From: Simon Davis
Sent: 15 November 2018 17:34
To: 'Peter Cleveland'
Subject: RE: AW/259/18/PL

From: Simon Davis [mailto:Simon.Davis@arun.gov.uk]
Sent: 12 October 2018 12:58
To: Peter Cleveland [REDACTED]
Subject: AW/259/18/PL

Block Plan 1 : 500

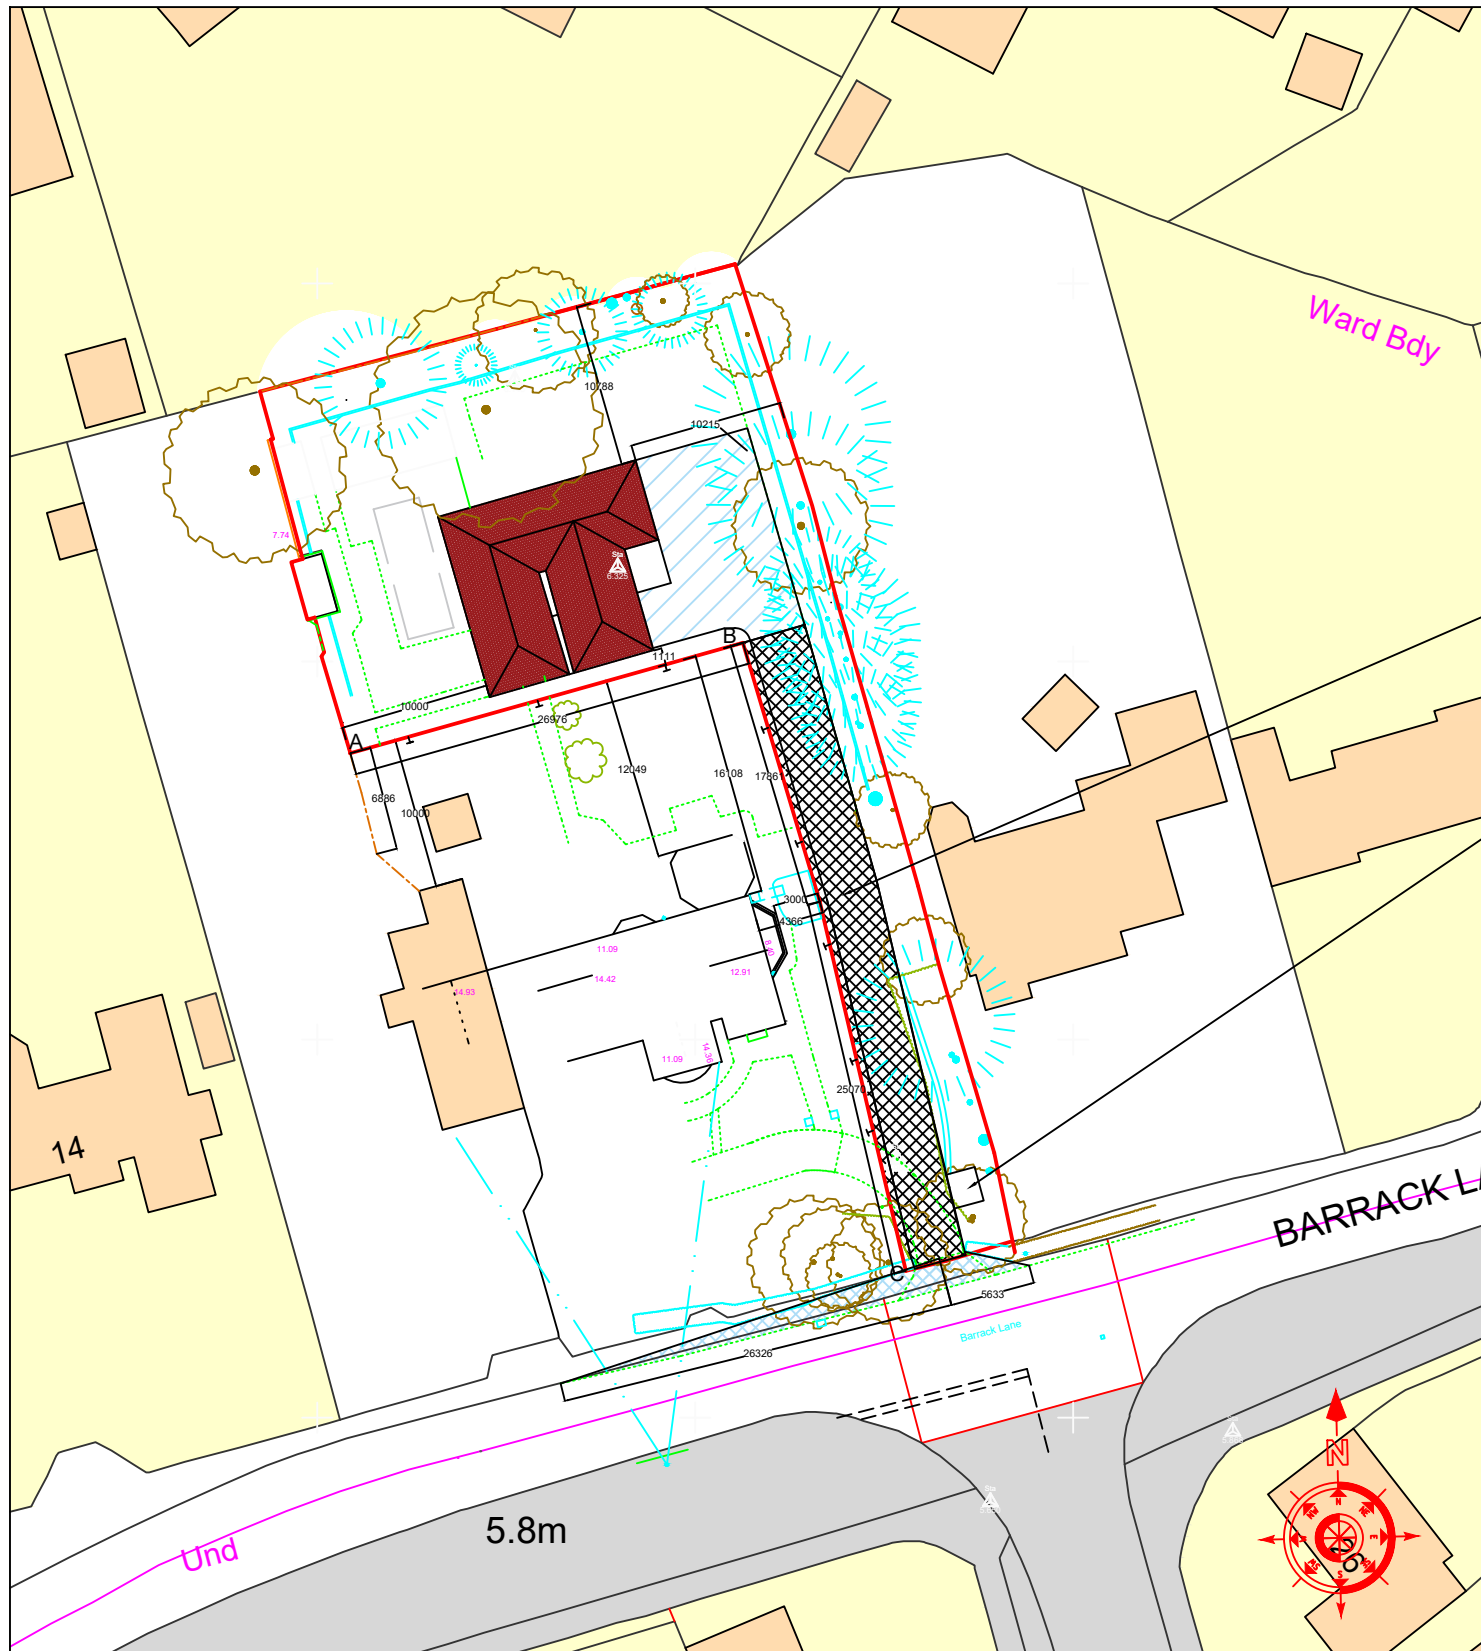
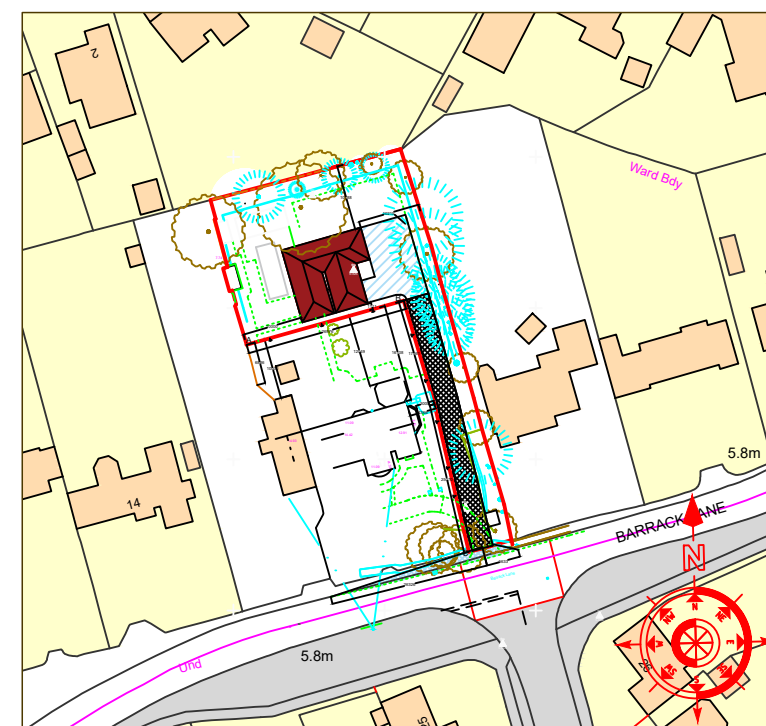
None of your plans have come out correctly in respect of the extent of the existing no. 10 (as I assume there is no proposal to demolish part of no. 10). See attached one of your plans that I have red ringed to show the issue.
